Appeal Decision

Appeal Ref: 6007885

20 Broadgate, Sutton St Edmund, Spalding, PE12 0LT

- The appeal is made under section 78 of the Town and Country Planning Act 1990 (as amended) against a refusal to grant planning permission.
 - The appeal is made by Mr and Mrs Ecuyer against the decision of South Holland District Council.
 - The application Ref is H19-1200-25.
 - The development proposed is a single storey side extension.
-

Proposed Elevations

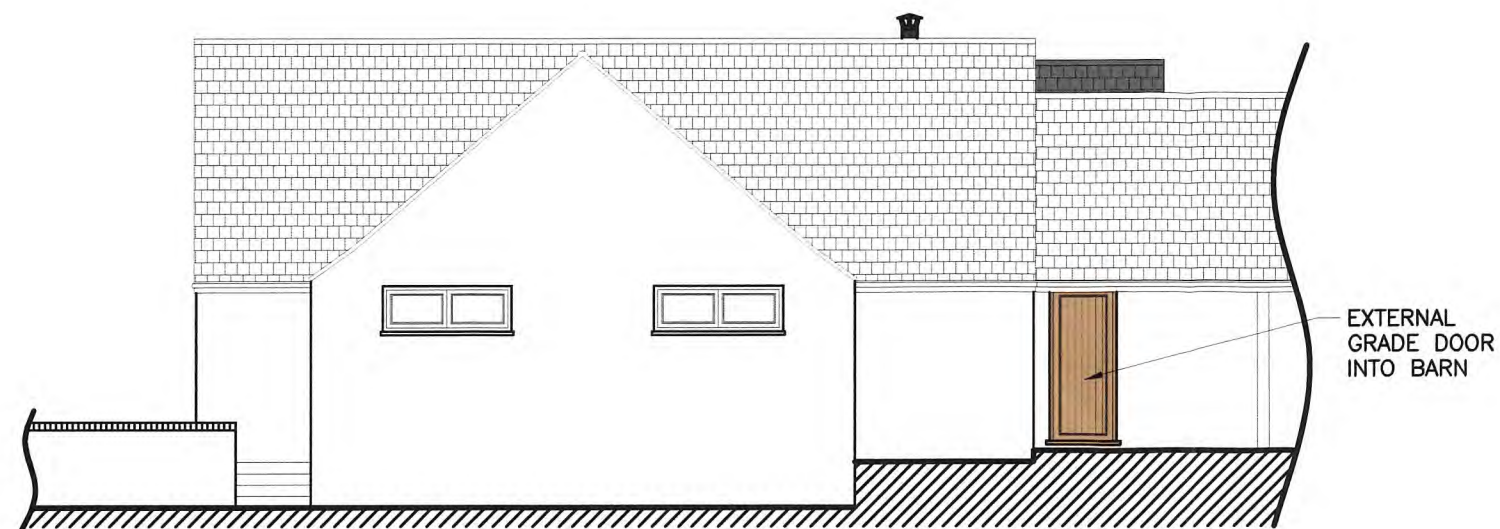
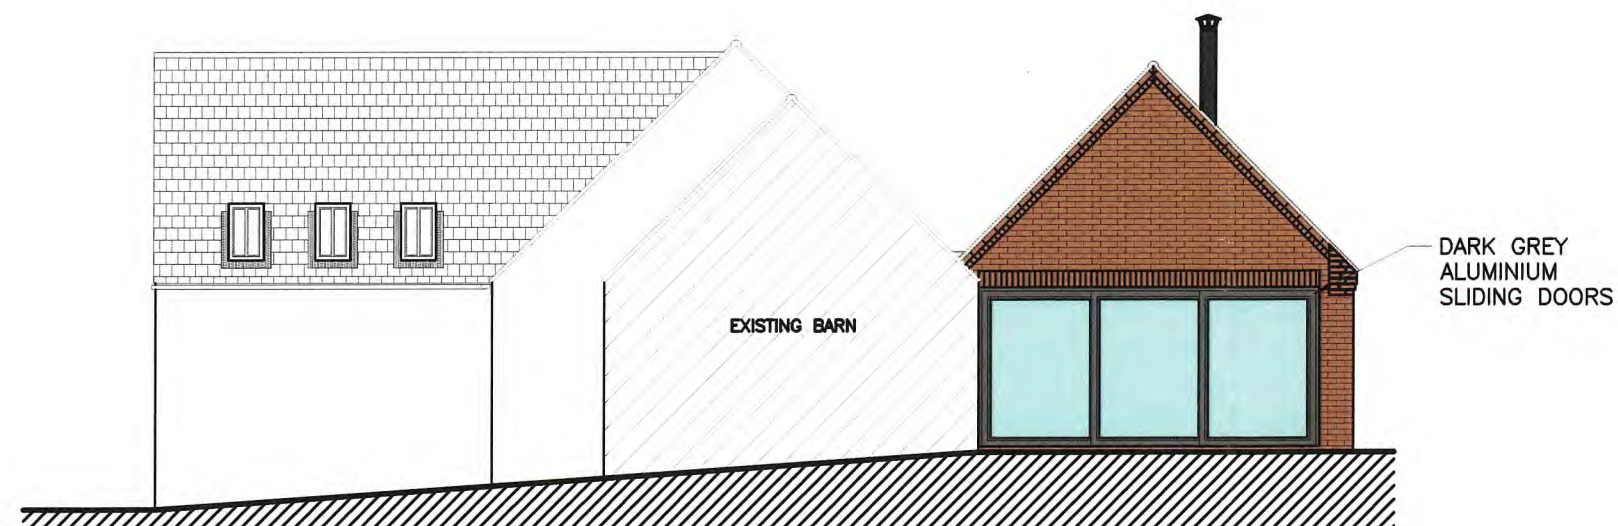
hallway for the modestly sized, one bedroom property. This elevation is little altered and retains its three original openings. Thus, despite the annexing of the building from the main farmhouse and the presence of the existing extension, this elevation contributes strongly to its cultural and architectural significance. The siting of an extension on this elevation would disrupt its existing linear form and would undermine its significance. The proposal would be accessed from the existing accommodation by one of the original openings but the siting of the extension would obscure this opening from view externally. Another existing opening would be partially bricked up externally. Those openings would therefore be significantly diminished and that would fundamentally harm the character and appearance of the building on this elevation.

5. The proposal would have a gabled roof with its gable end facing the road and at 90° to the main pitched roof. As such, it would appear almost as a separate rather than a related addition and its form would fail to integrate satisfactorily with the existing form of the original building. The height of the ridge would be only very slightly below that of the main ridge and the width of the gable end would be only slightly less than that of the gable end in the existing extension. The proposal would therefore fail to be sufficiently subordinate in terms of size and scale to the main building and would appear overly dominant. This would be exacerbated by the proposed cathedral style window in the upper part of the gable end. Cathedral windows are a feature of cathedrals, not agricultural buildings and that detail would therefore be incongruous in this building.

Proposed Floor Plan & Elevations

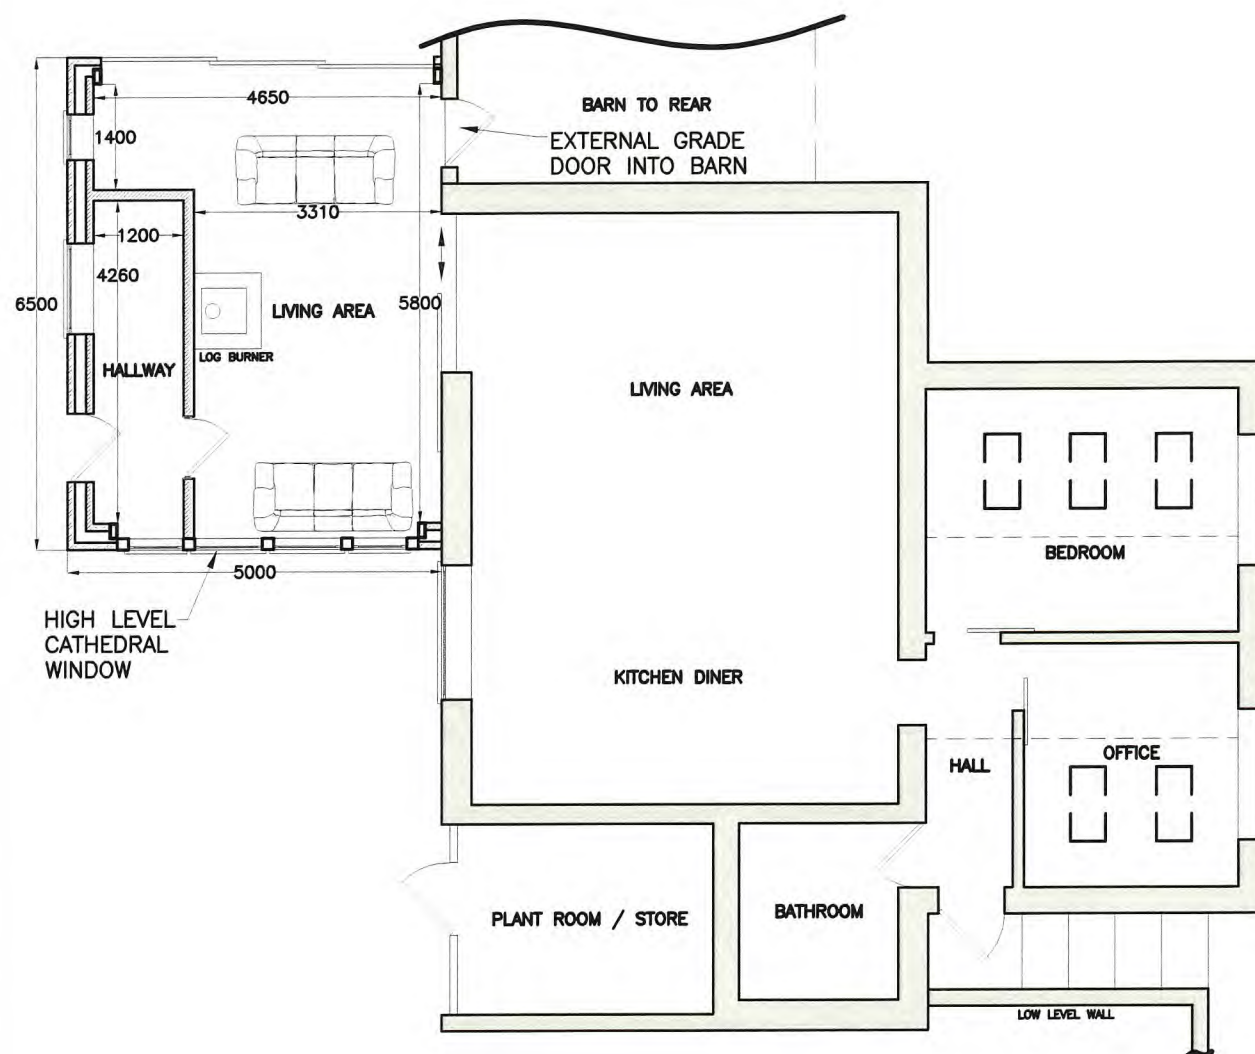
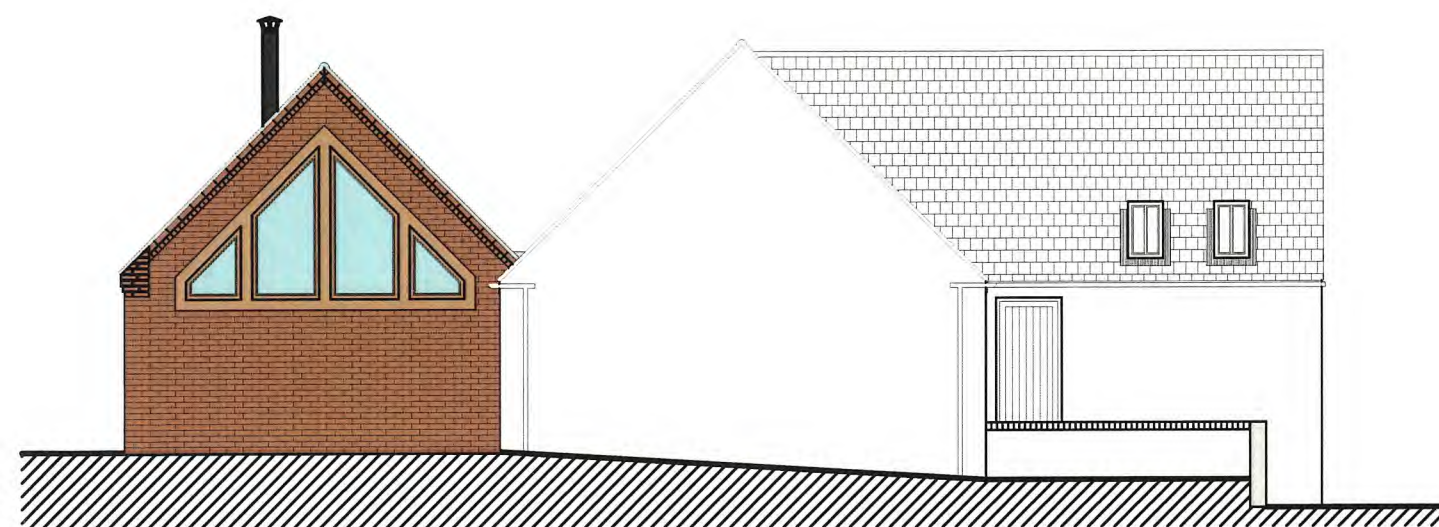
4. The building has a traditional linear form with a pitched roof of two different ridge heights and is positioned with its gable end to the road. It has been previously extended with a gabled roof on its southern side elevation which has partially obscured the original features on that side. This proposal is for an extension on the opposite, northern elevation which would provide a second living room and a

6. Whilst the extension would be set back by a few metres from the road, it would be clearly seen in public views in the approach from the north along this long, straight road as well as from outside the site and in private views from the dwelling opposite. Its uncharacteristic appearance would detract from the rural character of the area.
